Showcase Restoration

Client: Ellen Geddes
Property: 2817 Carolina Way
Sanford, NC 27332

Type of Estimate: Fire
Date Entered: 6/16/2025
Date Est. Completed: 6/16/2025

Price List: NCFA8X_JUN25
Labor Efficiency: Restoration/Service/Remodel
Estimate: GEDDESCHANGEORDER--1

N
↑
1st Floor

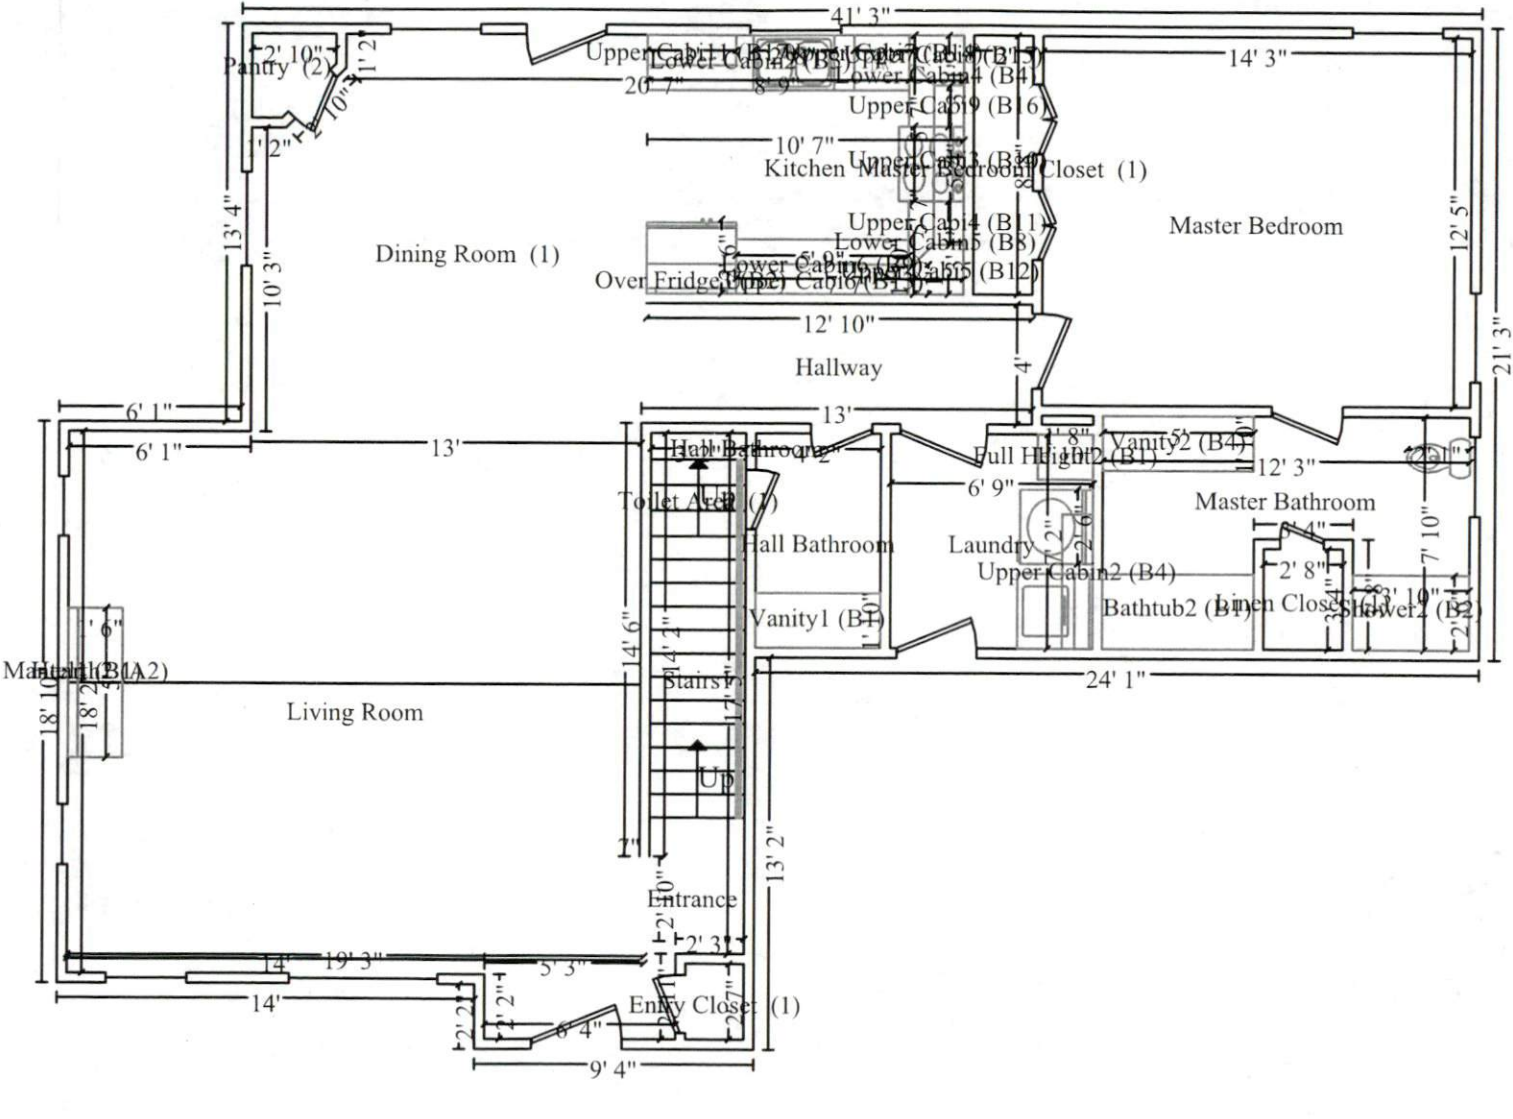
233. Protect contents - Cover with plastic	40.00 SF
Change Order	
252. Vinyl plank flooring	350.11 SF
274. Baseboard - Detach & reset Baseboards will have to be replaced to fit LVP under	52.71 LF

278. R&R Reducer strip - for wood flooring surround the fireplace, matches LVP	4.70 LF
279. Drywall Installer / Finisher - per hour labor to notch all door jambs and casing so LVP fits under- 20 minutes per door	0.20 HR

DESCRIPTION	QTY
228. Vapor barrier - 15# felt	51.84 SF
229. Final cleaning - construction - Residential	51.84 SF
232. Protect contents - Cover with plastic	40.00 SF
Change Order	
248. R&R 110 volt copper wiring run, box and GFI outlet	3.00 EA
3 GFIs installed on new kitchen wall	
254. Vinyl plank flooring	51.84 SF
280. Baseboard - Detach & reset	22.44 LF
Baseboards will have to be replaced to fit LVP under	
281. Drywall Installer / Finisher - per hour	0.40 HR
labor to notch all door jambs and casing so LVP fits under- 20 minutes per door	
282. Baseboard - 3 1/4"	3.00 LF
To cover new drywall area in hallway where door used to be	
283. Paint baseboard w/cap &/or shoe - two coats	3.00 LF

124. Mask the floor per square foot - plastic and tape - 4 mil protect tile floor from paint	44.11 SF
Change Order	
314. R&R Toilet	1.00 EA
move toilet to where existing sink is

315. Rough-in plumbing - per fixture	2.00 EA
move plumbing line to where existing sink is and one for the pedestal sink	
317. Remove Vanity with cultured marble or solid surface top	4.20 LF
remove vanity

318. Remove Tile floor covering	14.43 SF
remove tile from existing toilet area	
320. Remove 1/2" Cement board	14.43 SF
remove cement board from existing toilet area

331. Plumbing fixture supply line	1.00 EA
347. Underlayment - 1/2" OSB	14.43 SF
350. Water line copper cap/plug - per cap	1.00 EA
app	
239. Labor to frame 2" x 4" non-bearing wall - 16" oc	32.00 SF

351. 1/2" drywall - hung, taped, with smooth wall finish	32.00 SF
To close door to toilet room	
352. Tape joint for new to existing drywall - per LF	24.00 LF

146. Protect contents - Cover with plastic	65.00 SF
cover cabinets during repair	
Change Order	
244. Remove 1/2" drywall - hung, taped, floated, ready for paint	32.00 SF
Remove drywall to install door

245. Install Interior door unit	1.00 EA
Install door that was detached from hall bathroom	
246. R&R Casing - 3 1/4"	16.00 LF
install new casing on door	
247. Paint casing - one coat	16.00 LF

DESCRIPTION	QTY
222. Final cleaning - construction - Residential	263.93 SF
Change Order	
234. Remove 1/2" drywall - hung, taped, floated, ready for paint	97.00 SF
tear wall behind upper cabinets

242. R&R Refrigerator/icemaker water supply box with valve	1.00 EA
Remove from demo wall and install on new wall	
243. Rough-in plumbing - per fixture	1.00 EA
re-route plumbing line to new area for icemaker

260. Vinyl plank flooring	299.93 SF
36 additional SF for the flooring that will go under the demo wall	
287. Drywall Installer / Finisher - per hour	0.40 HR
labor to notch all door jambs and casing so LVP fits under- 20 minutes per door, back door and pantry

288. Underlayment - 5/8" OSB	64.00 SF
Installed to level floor where hardwood and walls were removed so LVP is installed evenly.	
292. Sink - single - High grade	1.00 EA
apron sink
